RE: **Pitcher Residence**
12000 San Antonio NE
Grading Plan Stamp Date: 2/18/20
Hydrology File: E22D007H1

Based on the submittal received on 2/20/20, the grading plan is approved for Grading Permit.

RE: Pitcher Residence
12000 San Antonio NE
Grading Plan Stamp Date: 11/14/19
Hydrology File: E22D007H1

Based on the submittal received on 11/18/19, the grading plan cannot be approved until the following corrections are made:

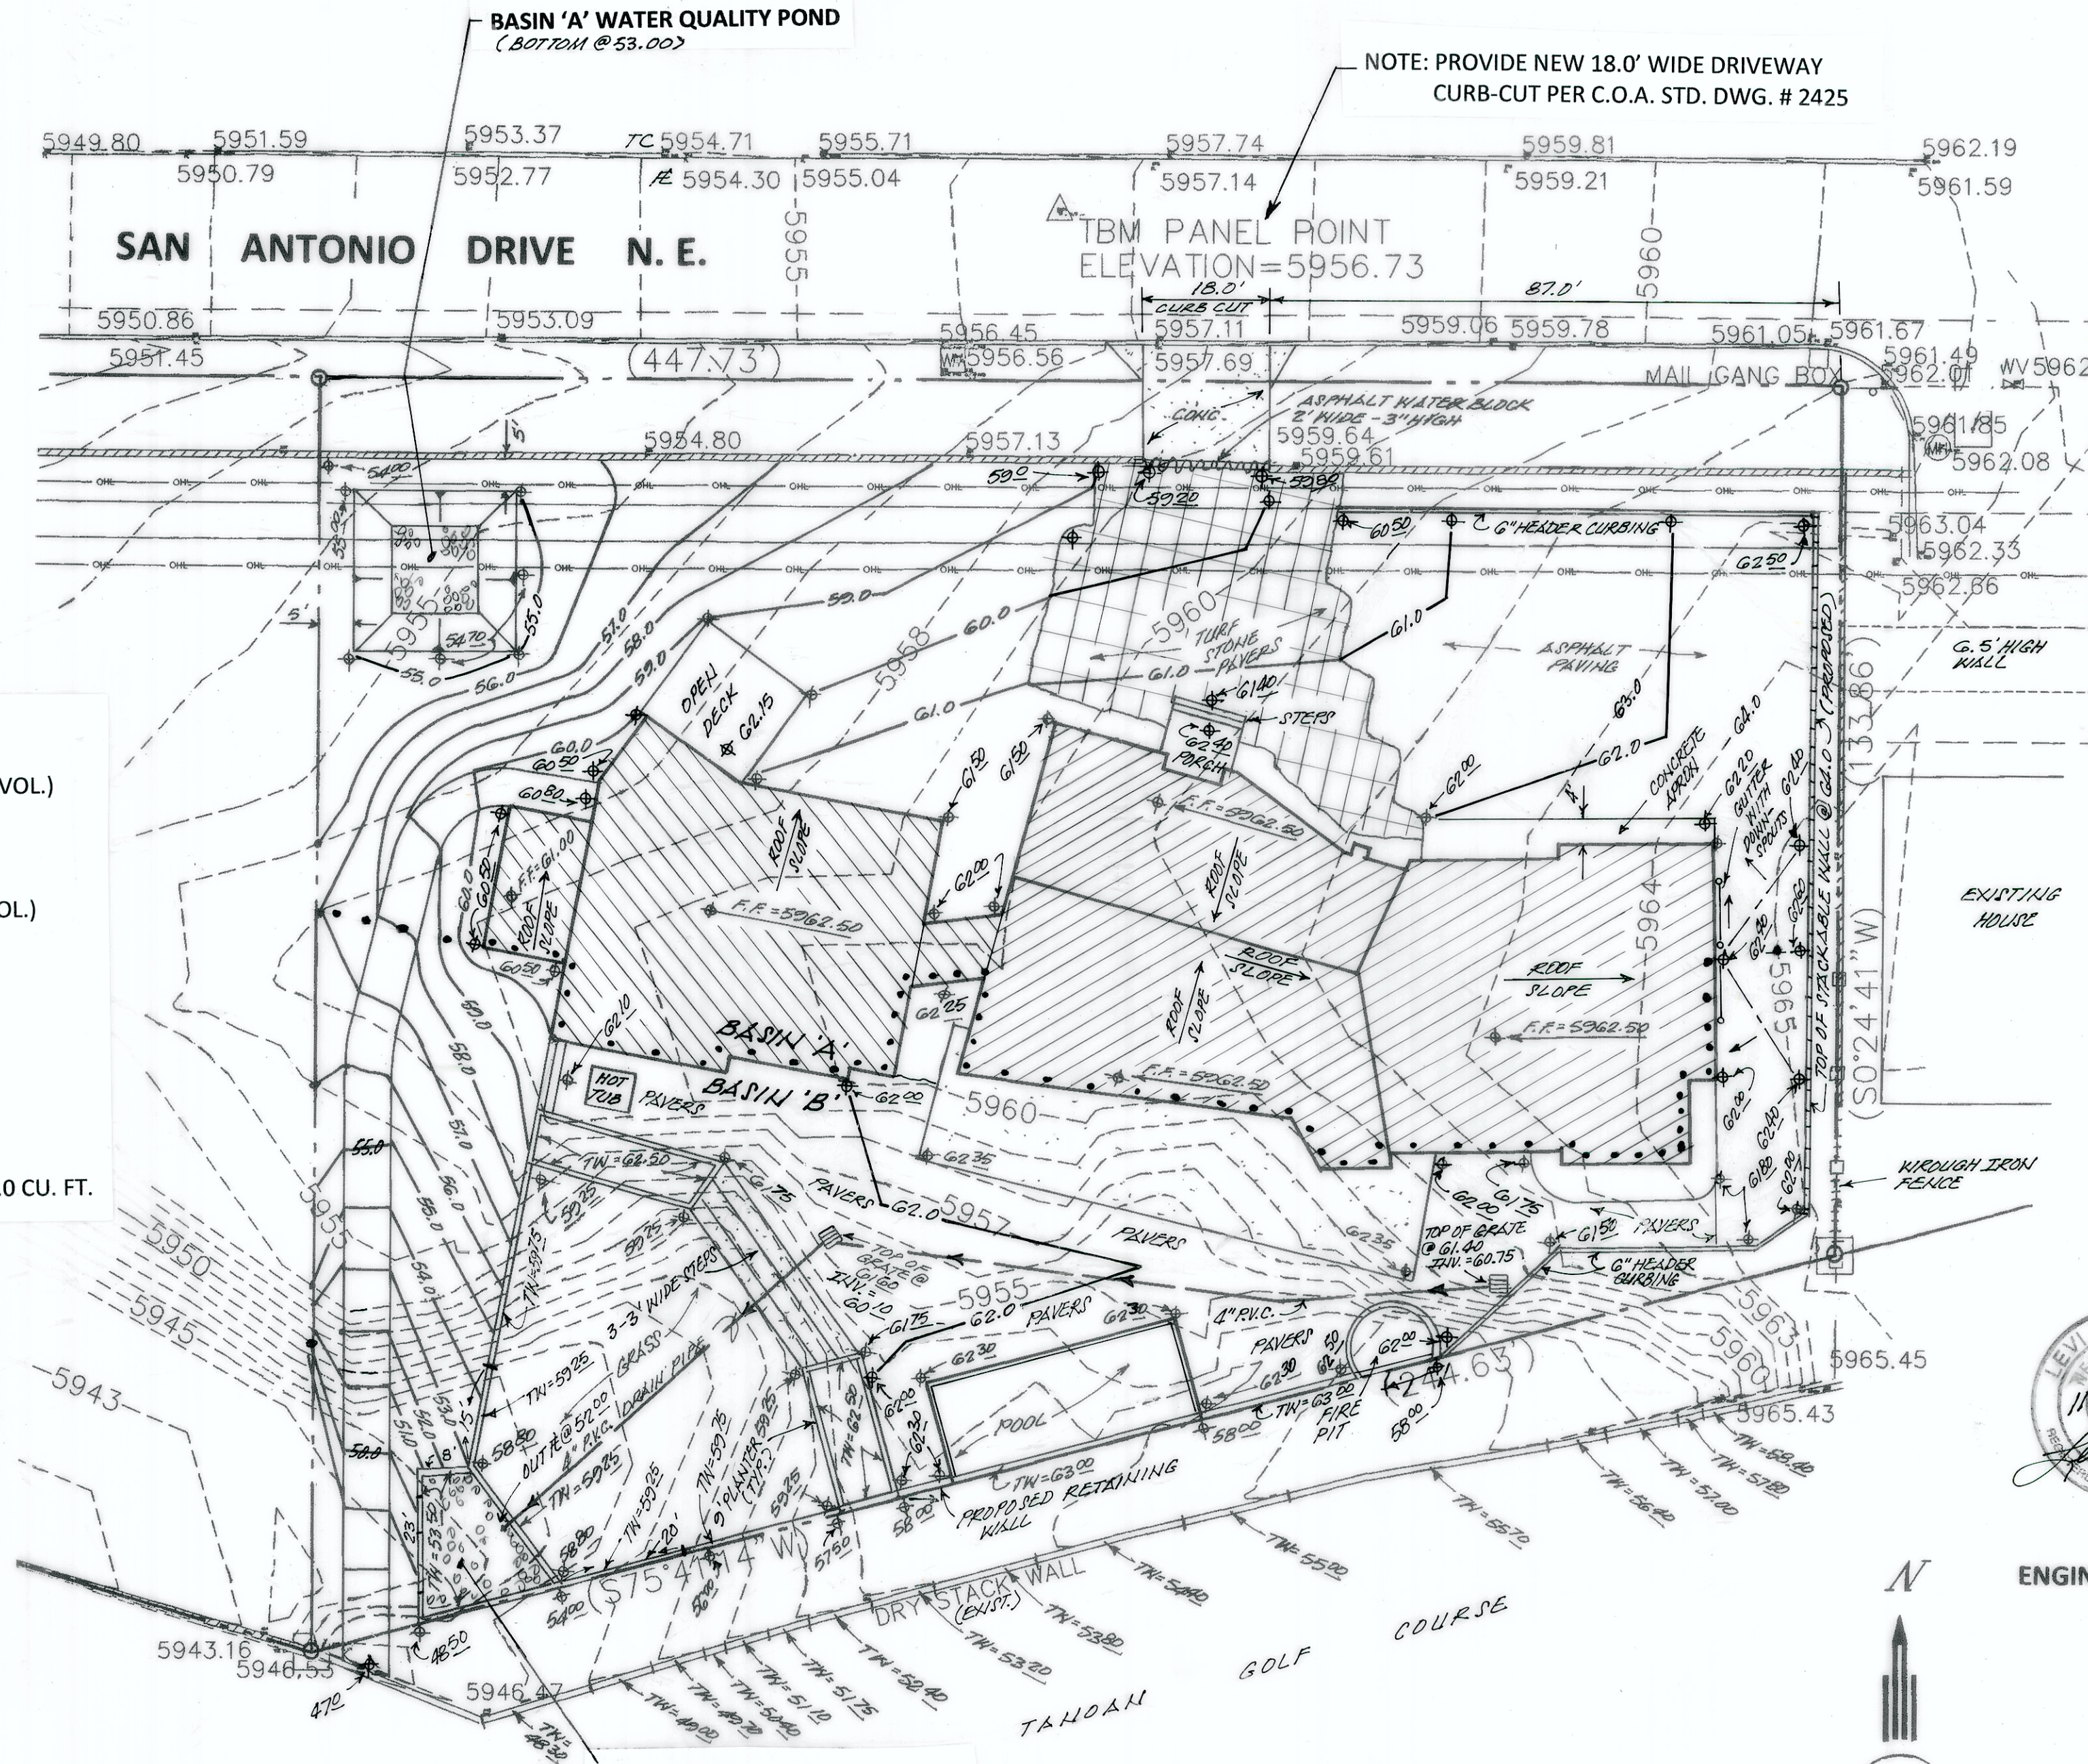
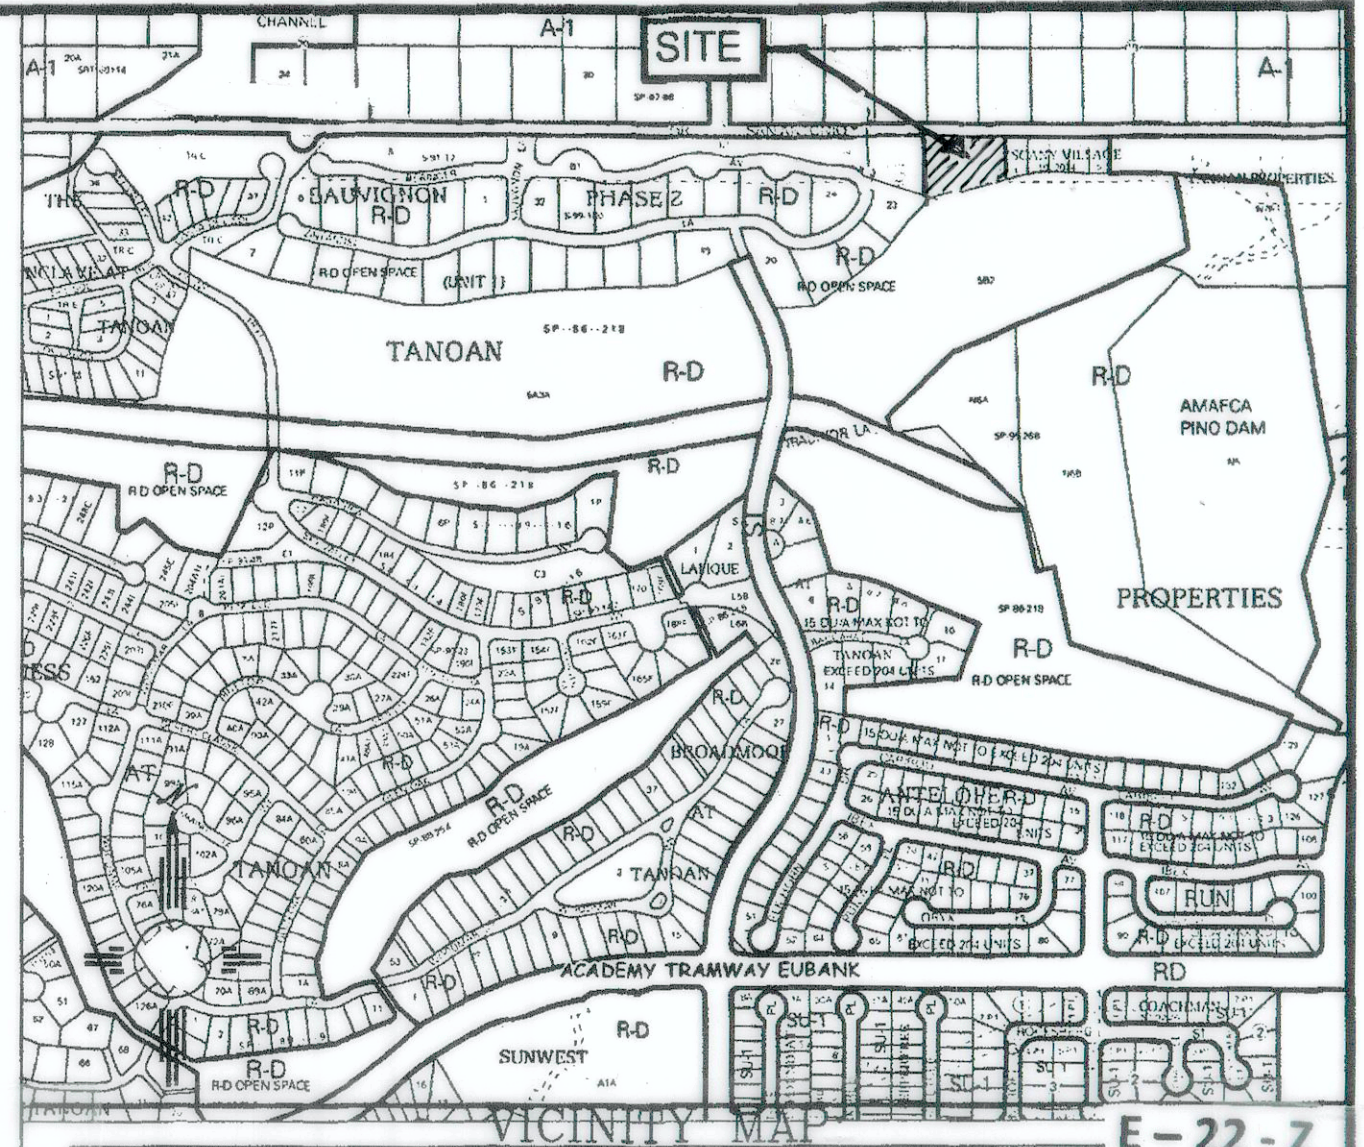
1. Show all easements of record and any utilities. **EASEMENTS SHOWN.**
2. Do not cut the grade or place and buildings in the PUE. **REFER TO ATTACHED P.N.M. APPROVAL DOCUMENT.**

3. Provide written and signed permission from PNM for grading, paving and building construction in their easement. **REFER TO ABOVE ITEM 2.**
4. Provide written and signed permission from the property owner to the south to discharge to their property. Per the approved conceptual grading and drainage plan for this site, no discharge to the south was permitted. **NO DISCHARGE TO SOUTH GOLF COURSE PROPERTY.**

5. Along the south property line, why are the spot elevations on the golf course property shown as several feet higher than the contours? If these are proposed elevations, provide written and signed permission from the adjoining property owner for grading their property. If this is new **REFER TO RESUBMITTAL PLAN AND RECORDED DOCUMENT WITH GOLF COURSE PROPERTY.**

survey, then the contours should match: **NEW GRADING REFER TO PLAN**

6. Provide sections through all external boundaries showing proposed retaining walls, garden walls, property/ROW lines, existing and proposed grades. In accordance with DPM Ch.22, section 5 part B, grading and wall construction near the property line may not endanger adjacent property or constrain its use. **SHOWN ON PLAN**

7. Proposed grades do not tie-in to existing at the SW corner:

8. Include project datum; all elevation need to be provided in NAVD88. **SHOWN ON PLAN**

REFER TO
RESUBMITTAL
PLAN
